Recommendation Report for Works to Tree(s) on trees subject to a Tree Preservation Order (TPO)

REF NO: AW/236/19/T

LOCATION: Royal Bay Court
86A Barrack Lane
Aldwick
PO21 4DY

PROPOSAL: Crown reduction 4m on north aspect and 2.5m on other aspects to 1 No. Willow tree.

REF 1

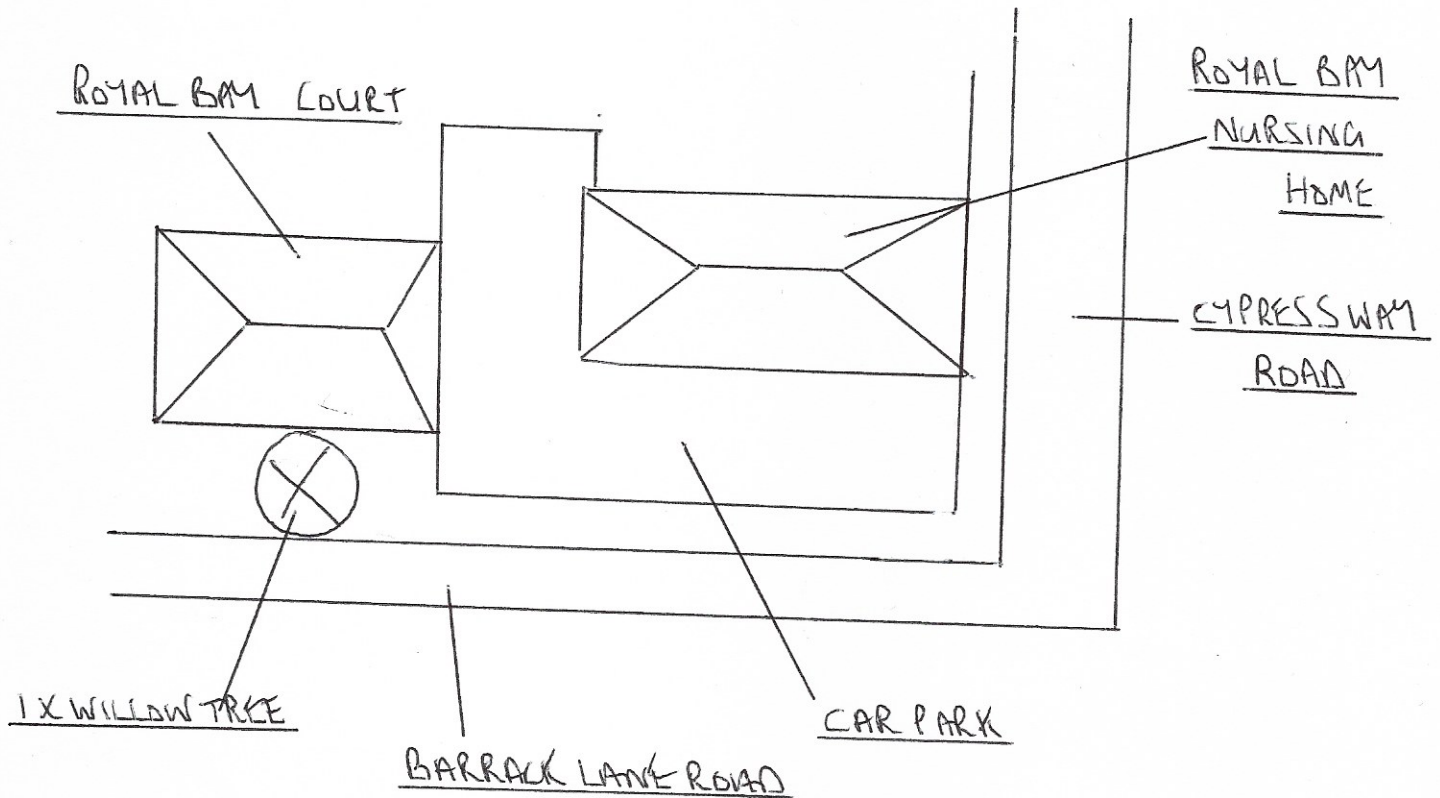
· The map provided with the application does not seem to reflect the physical features on the ground and so the marked location of the tree is not helpful. That said, I have sought verbal confirmation from the applicant who confirms the tree subject of this application is the large, obvious and only mature willow on the site.
